**Re: PCD File No. PPR2329  
The Rock Commerce Center, 1st Review  
Response to Comments**

Please accept this letter on behalf of Central Development, LLC, the applicant for The Rock Commerce Center. We received your comment letter dated November 9, 2023, regarding the application and we offer the following responses:

SHEET
C3.0

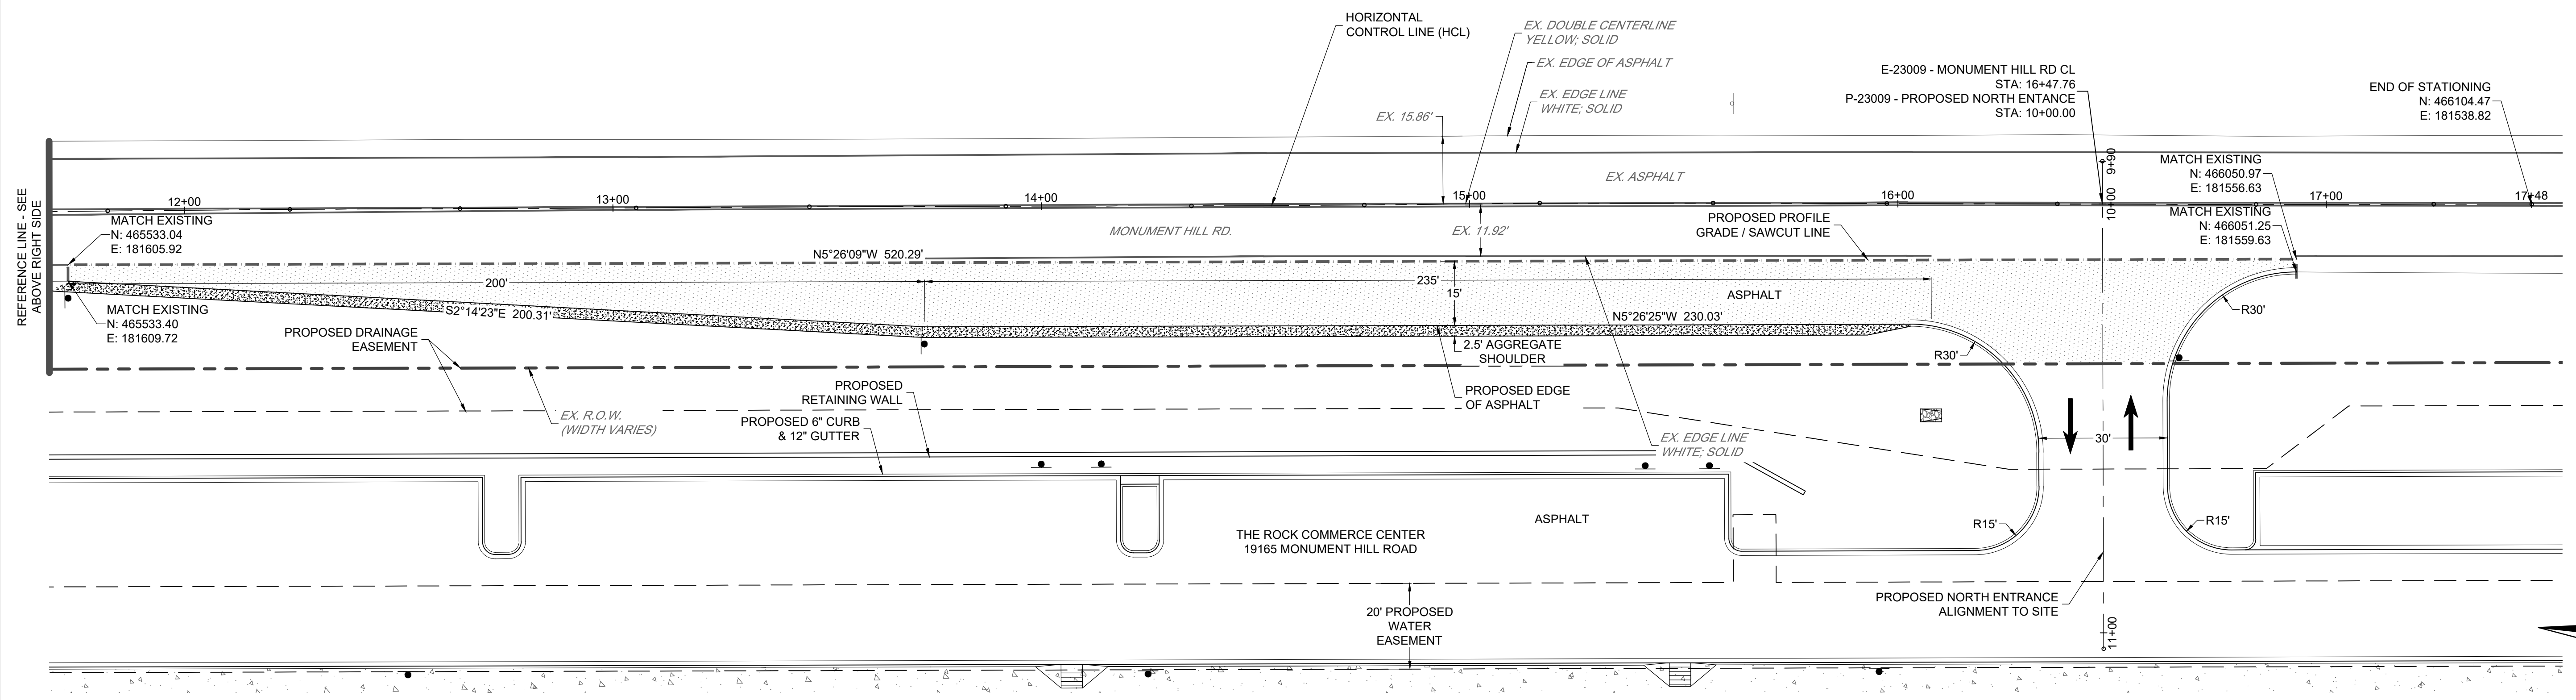
10. Provide detail & dimensions of outlet protection.

**Response:** The riprap was labeled with type, thickness, length, and depth. The MHFD standard detail for riprap was added to the detail sheets at the end of the Public Improvement Plans.

SHEET
C4.0

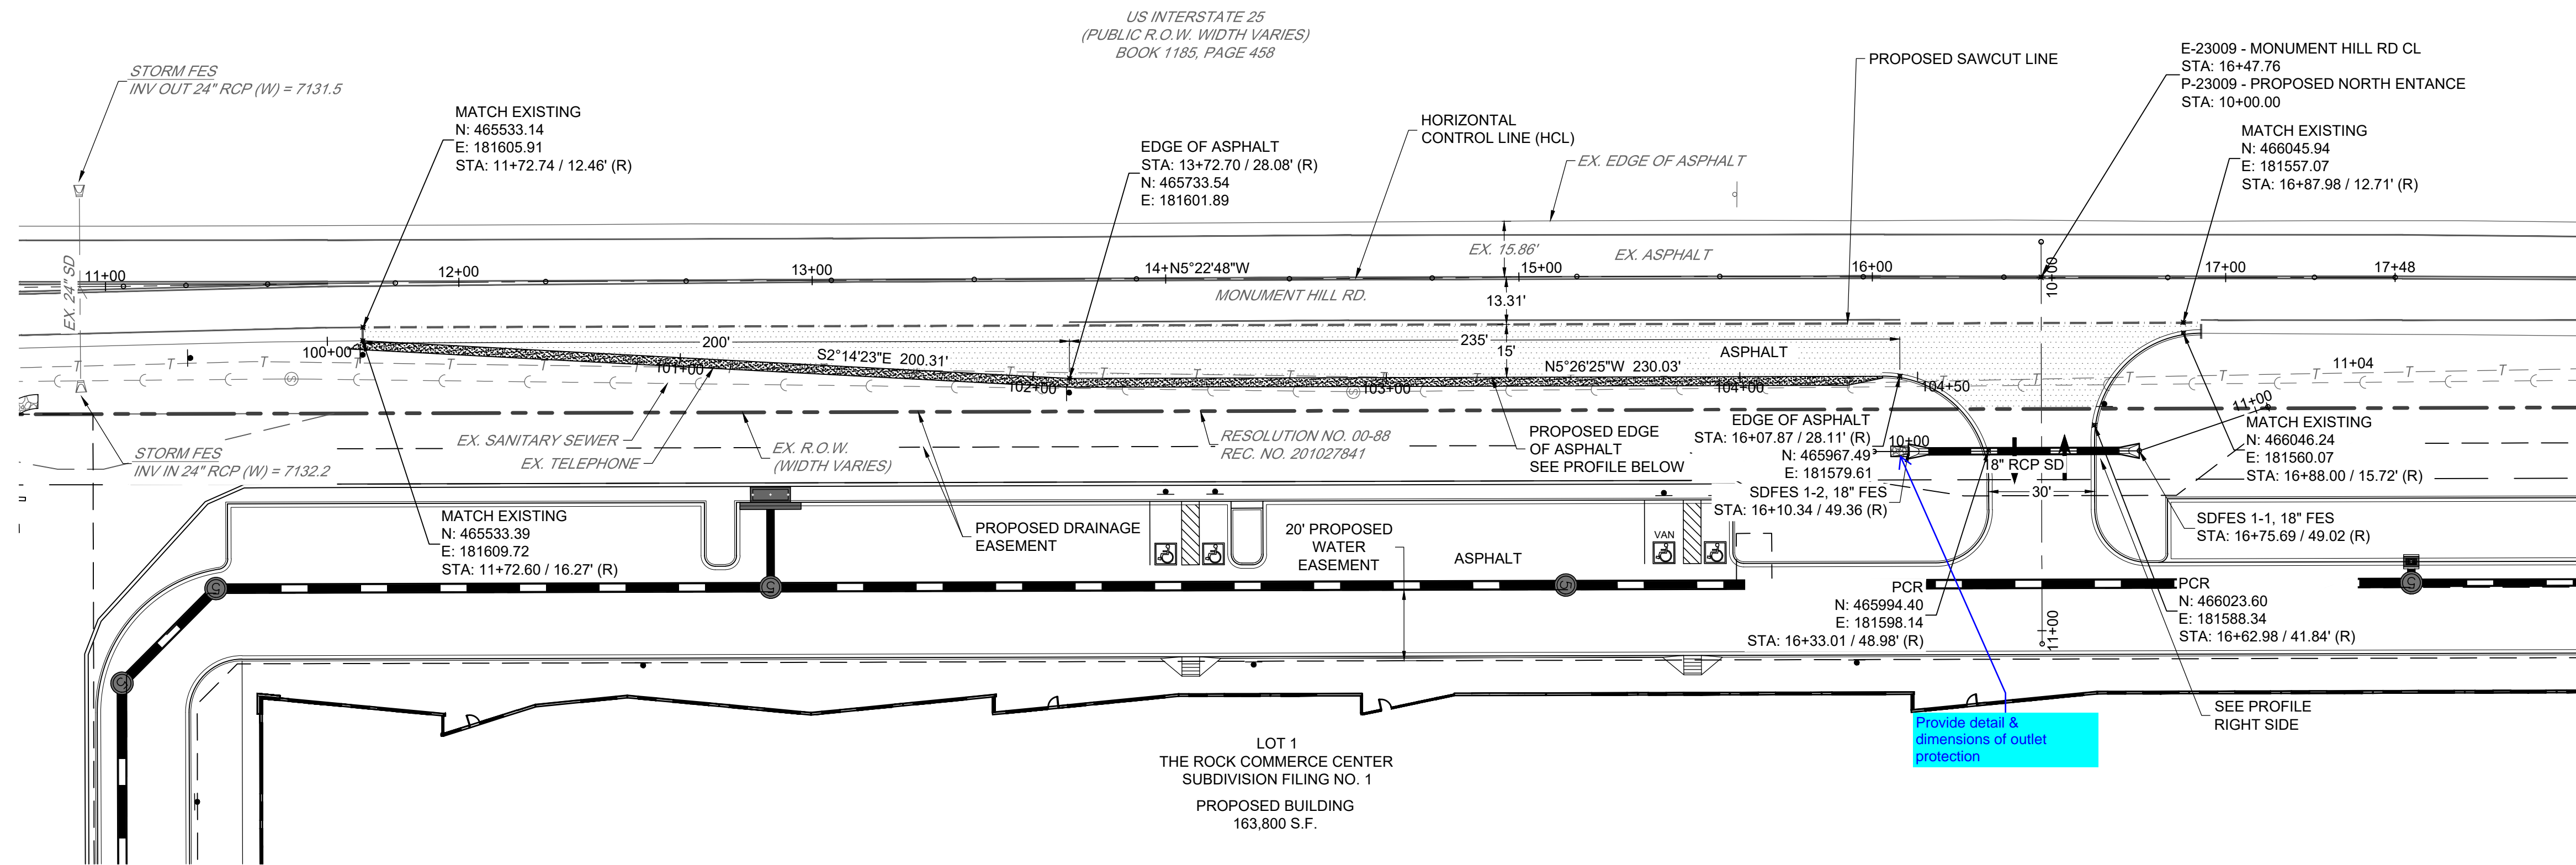
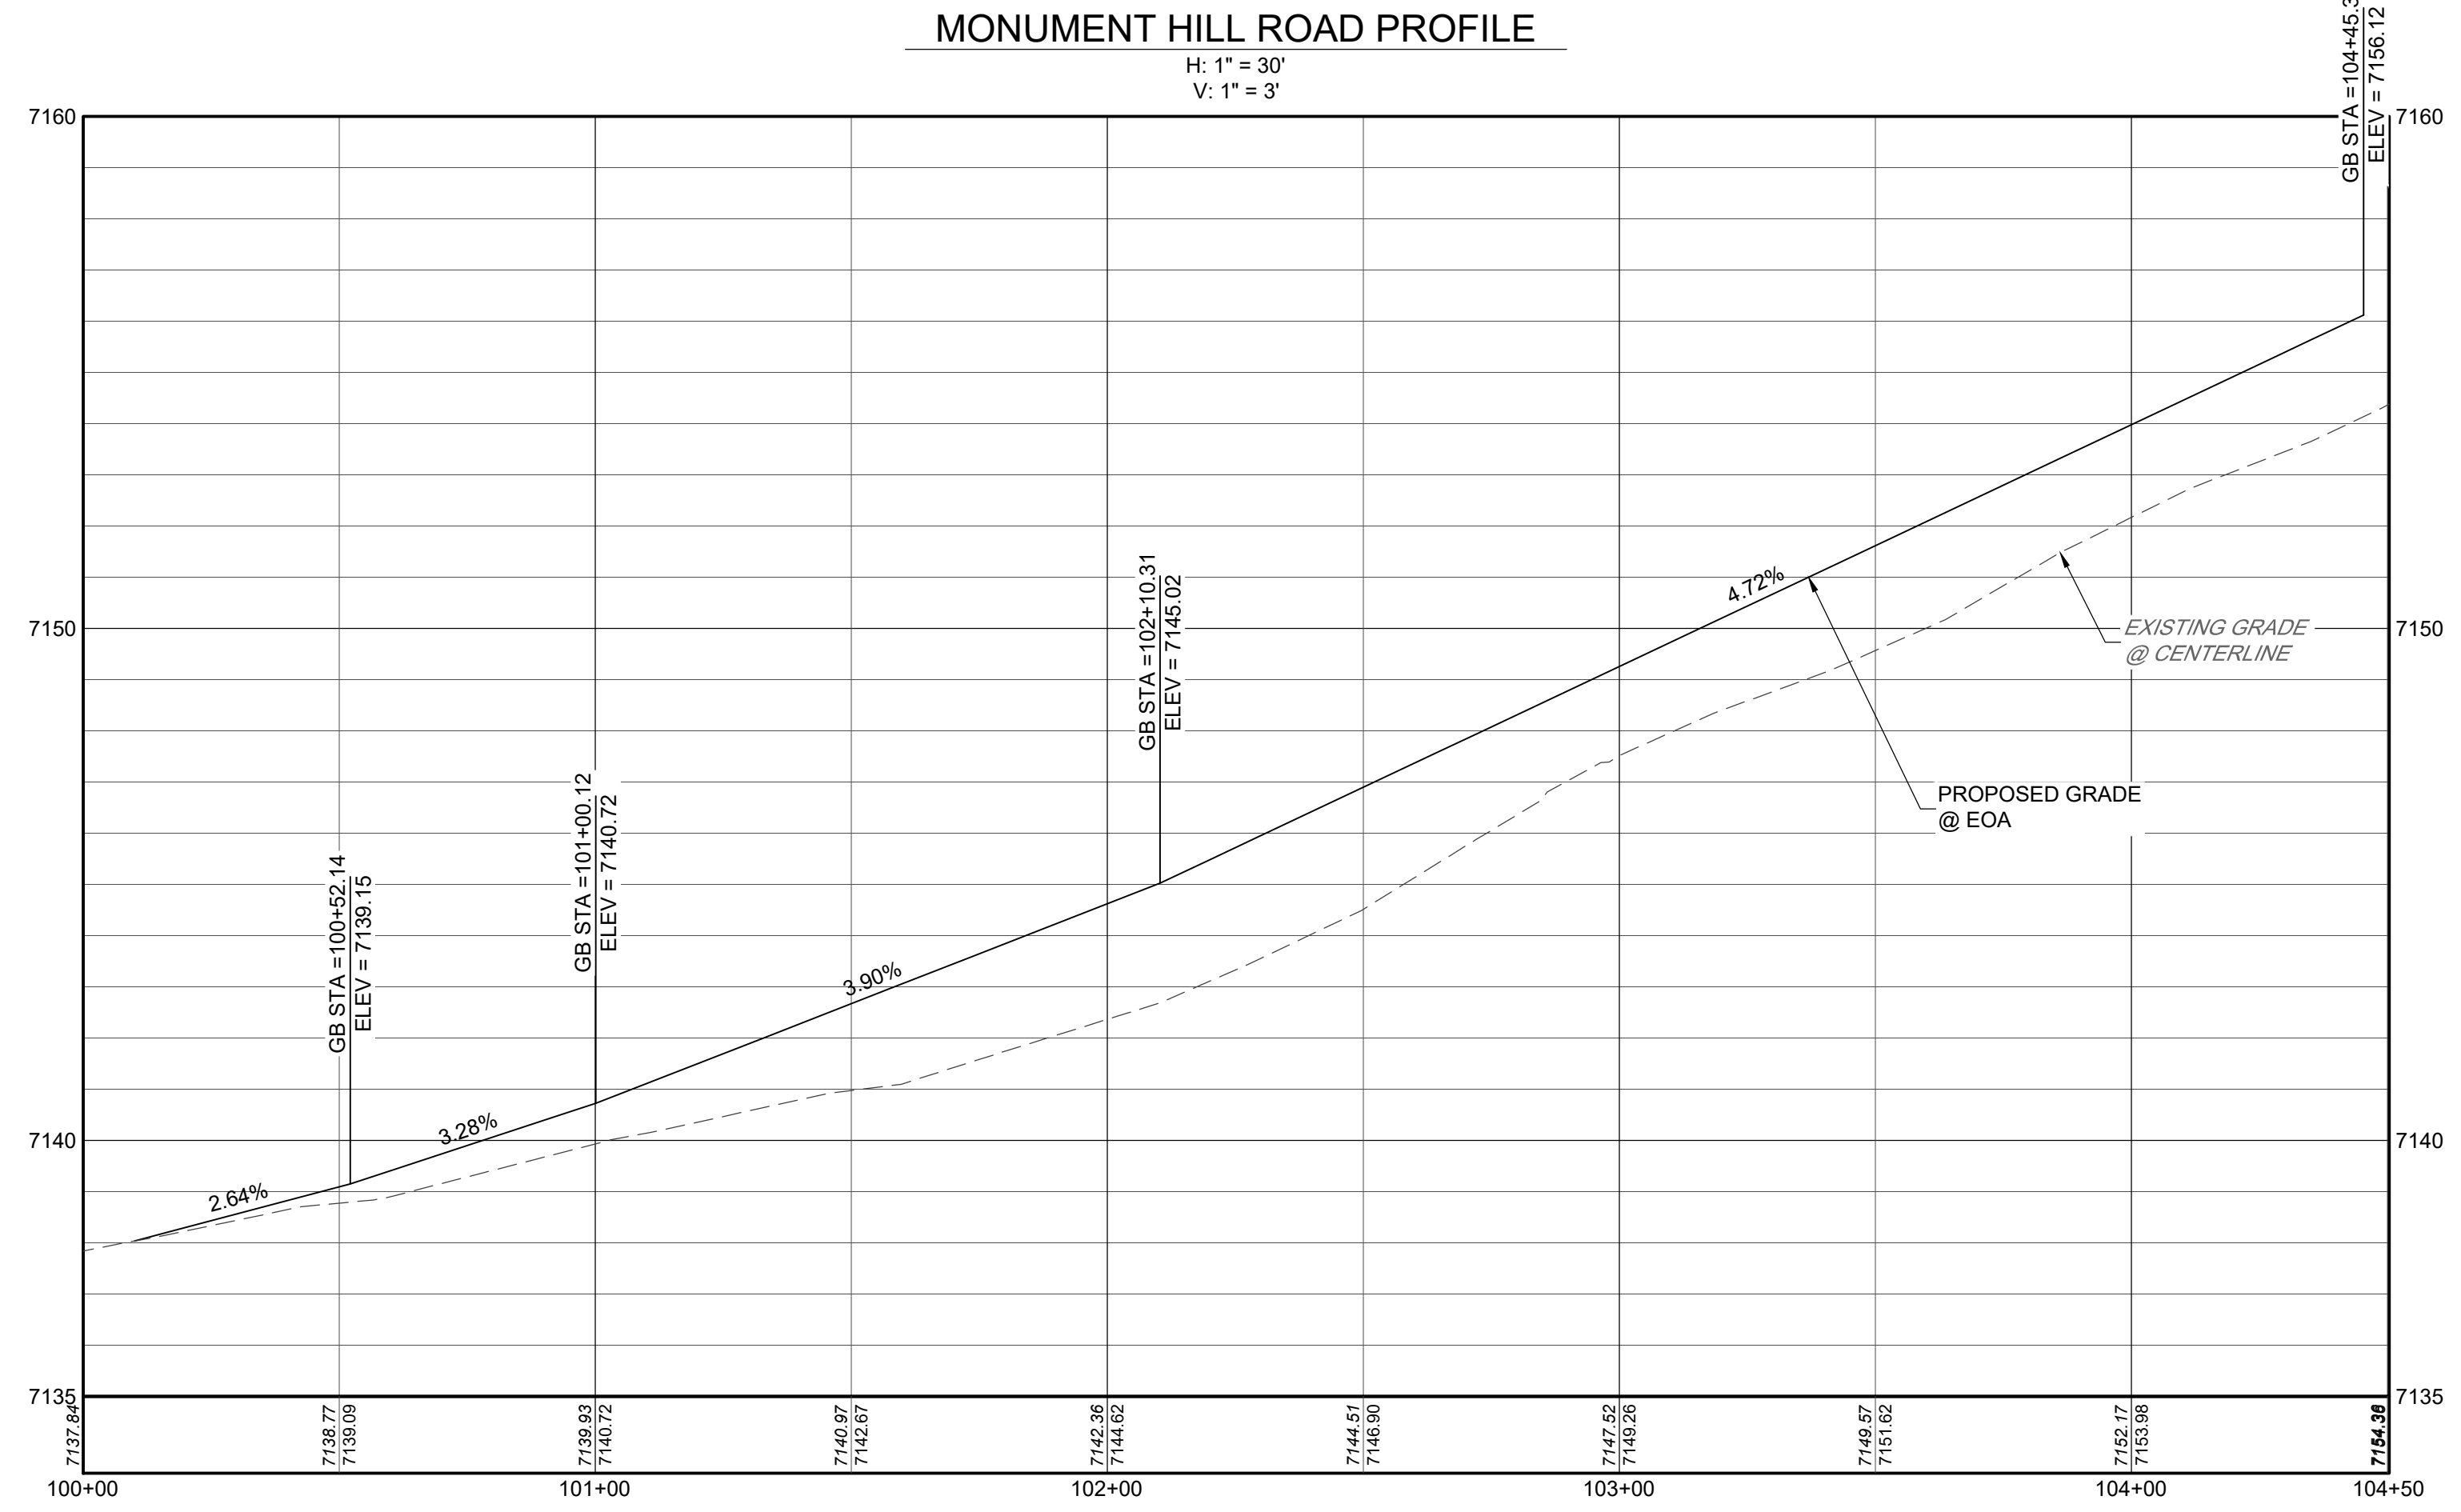
11. Provide detail & dimensions of outlet protection.

12. Per ECM Section 4.3.6.A.3 minimum cover over a culvert/storm is 2.0’.

13. Riprap appears to be higher than grading from culvert/FES.

**Response:** The riprap was labeled with type, thickness, length, and depth. The MHFD standard detail for riprap was added to the detail sheets at the end of the Public Improvement Plans.

**Response:** The culvert under the proposed access drive was lowered to provide 2 feet minimum of cover for the culvert.

**Response:** The riprap was fixed in the profile view to display correctly.
